**EL PASO COUNTY PLANNING AND
 COMMUNITY DEVELOPMENT
 DEPARTMENT**

STORMWATER MANAGEMENT PLAN CHECKLIST

Revised: July 2019

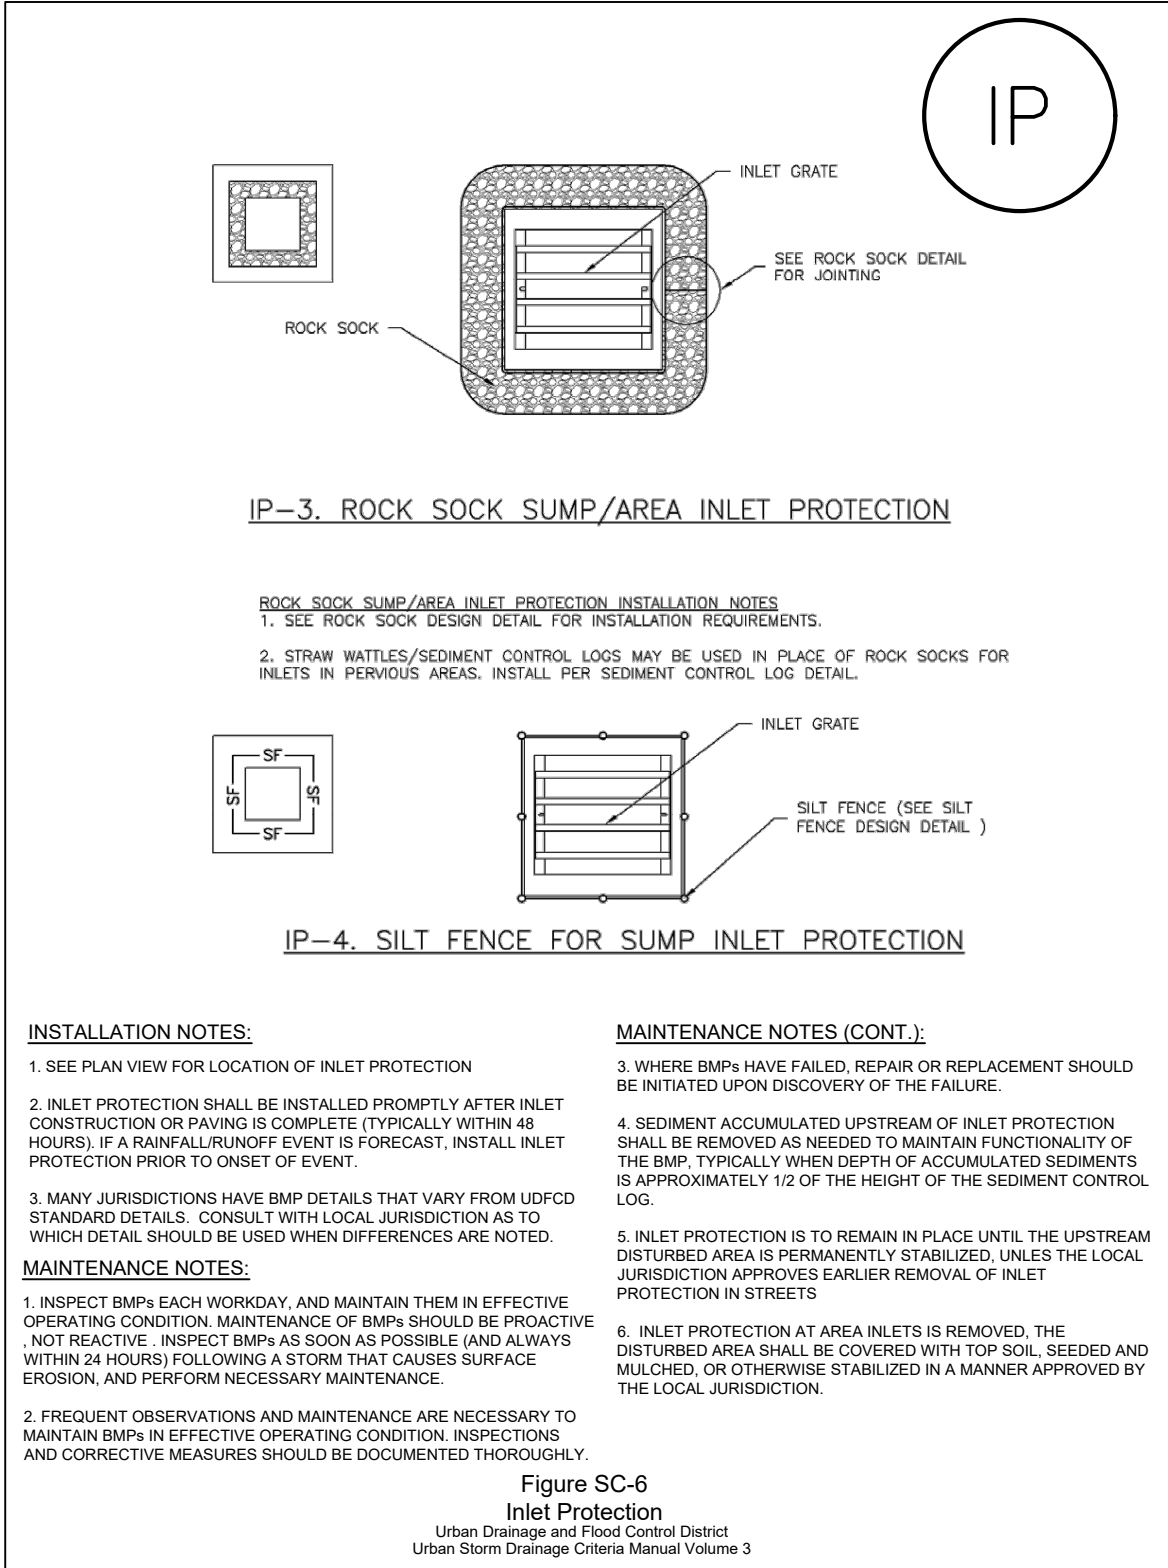
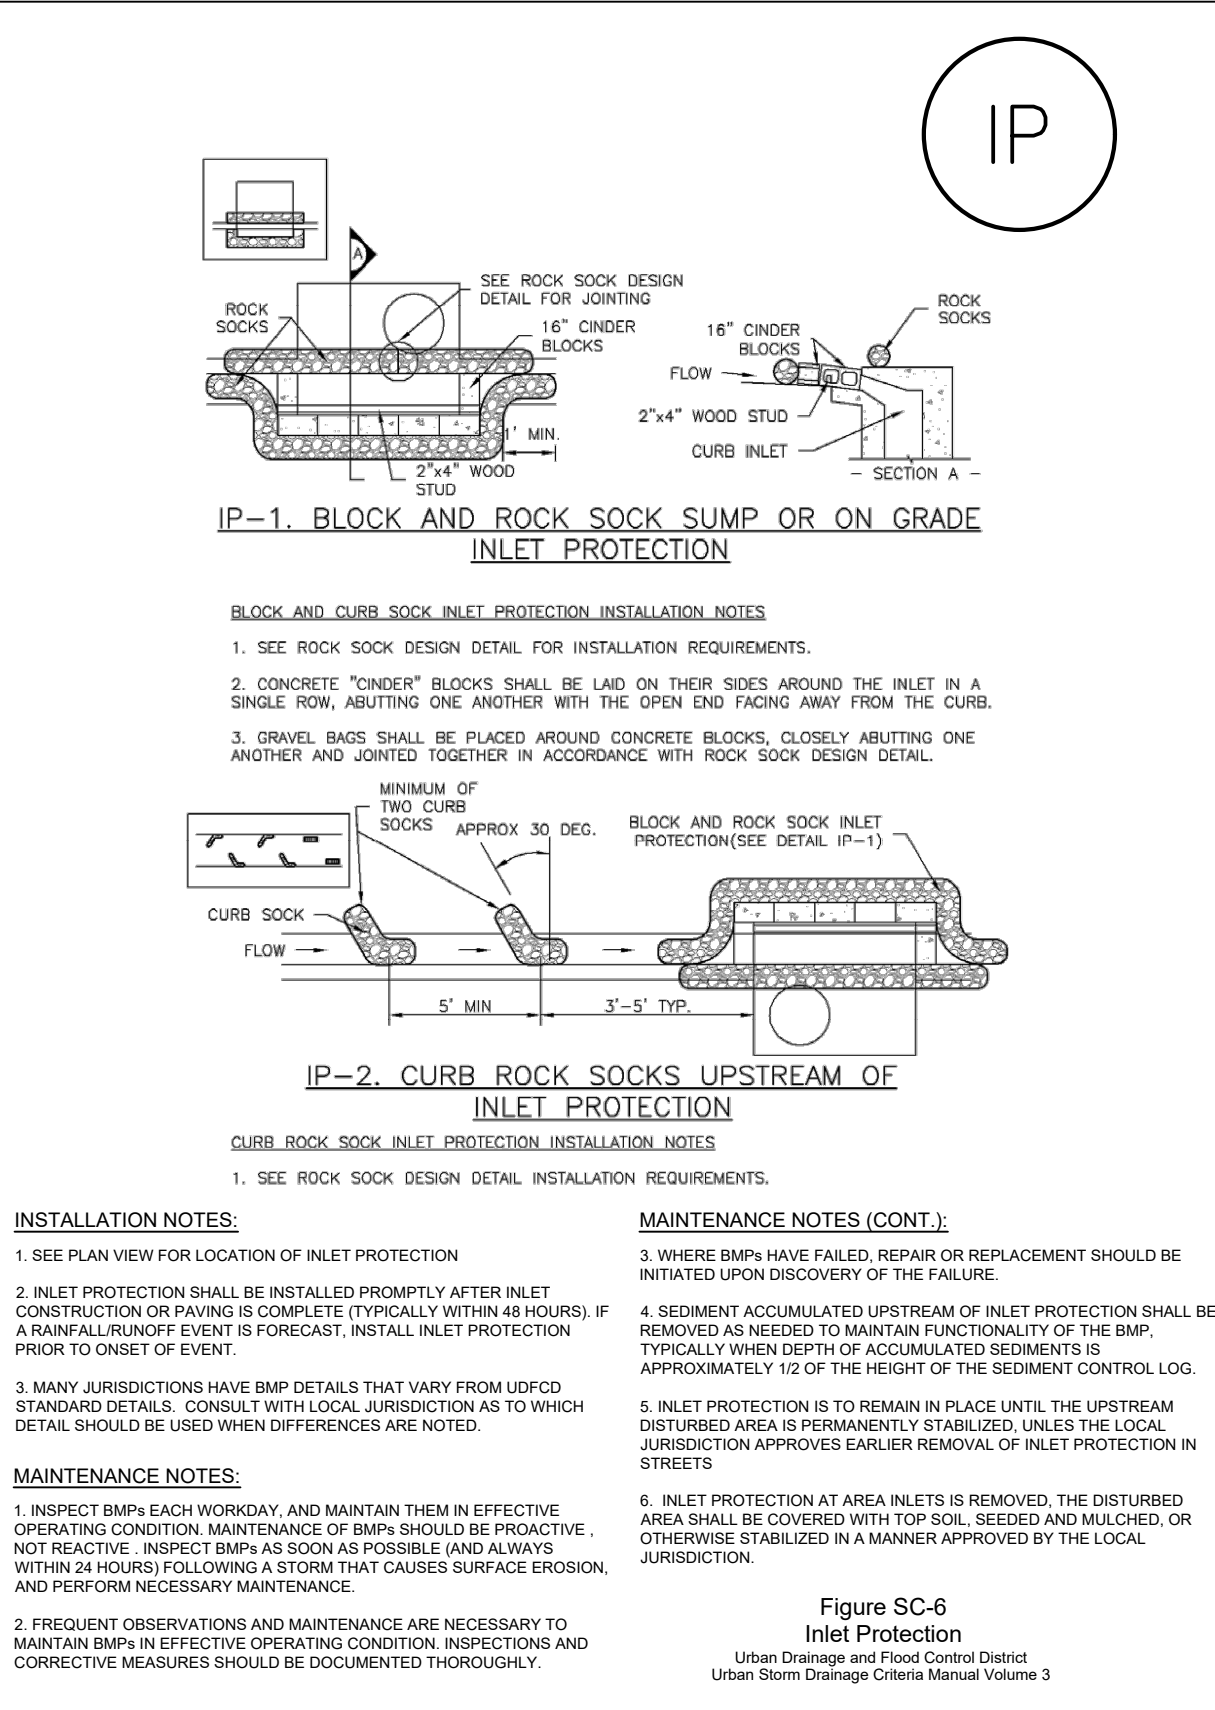
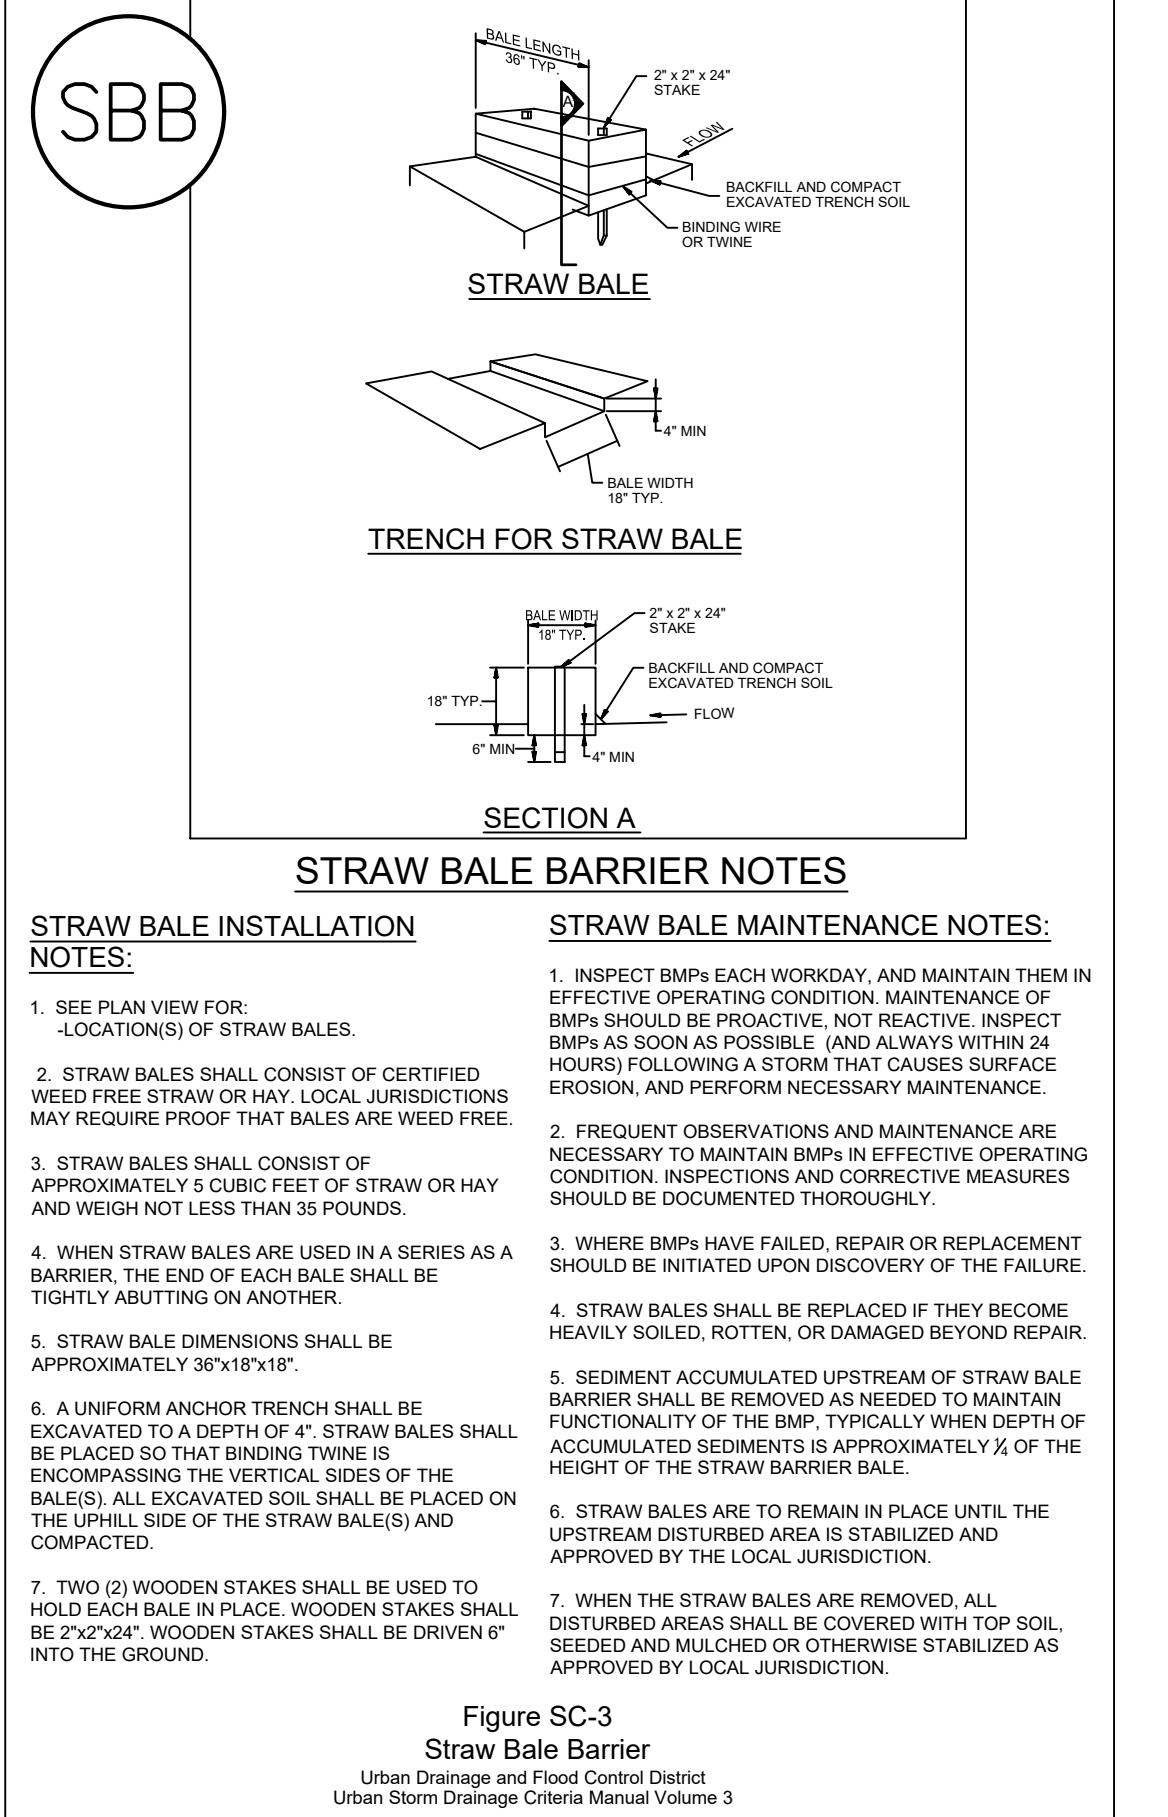
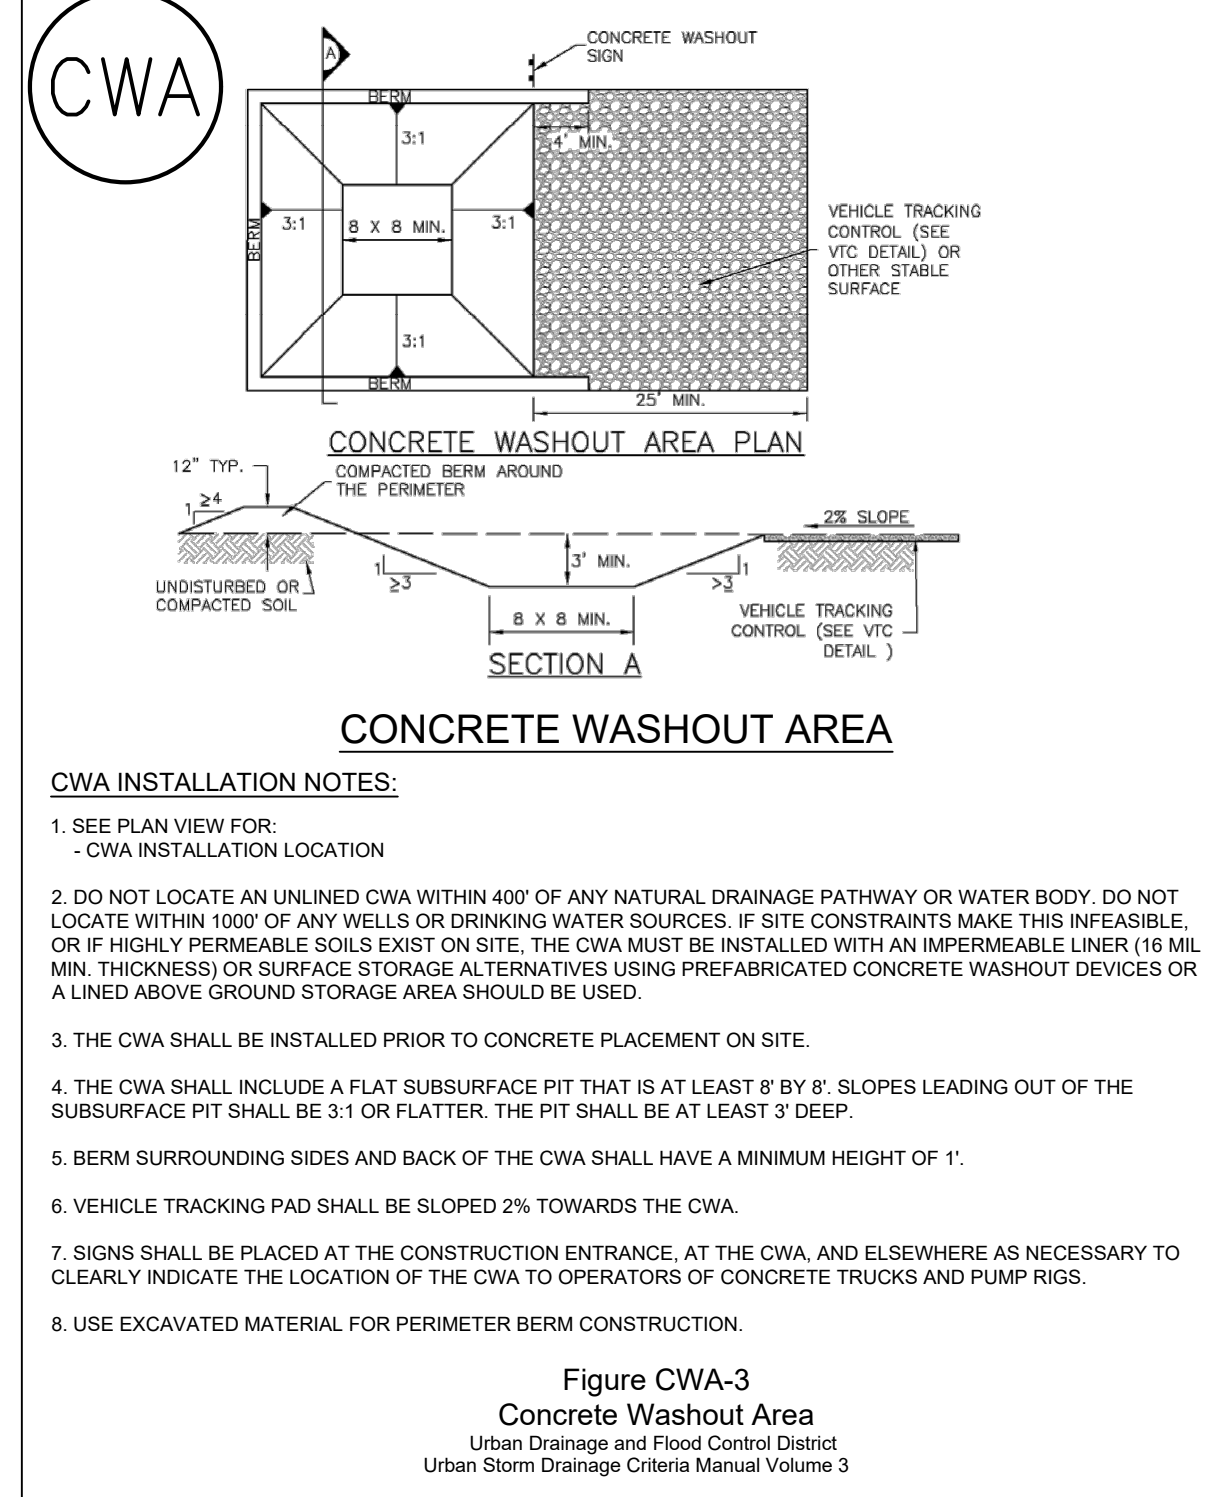
20	Technical drawing details for all control measure installation and maintenance; custom or other jurisdiction's details used must meet or exceed EPC standards Include detail for Mulching		X
21	Procedure describing how the SWMP is to be revised		X
22	Description of Final Stabilization and Long-term Stormwater Quality (describe nonstructural and structural measures to control SW pollutants after construction operations have been completed, including detention, water quality control measure etc.)		✓
23	Specification that final vegetative cover density is to be 70% of pre-disturbed levels		✓
24	Outline of permit holder inspection procedures to install, maintain, and effectively operate control measures to manage erosion and sediment		X
25	Record keeping procedures identified to include signature on inspection logs and location of SWMP records on-site See note on pg 24		X
26	If this project relies on control measures owned or operated by another entity, a documented agreement must be included in the SWMP that identifies location, installation and design specifications, and maintenance requirements and responsibility of the control measure(s).		X
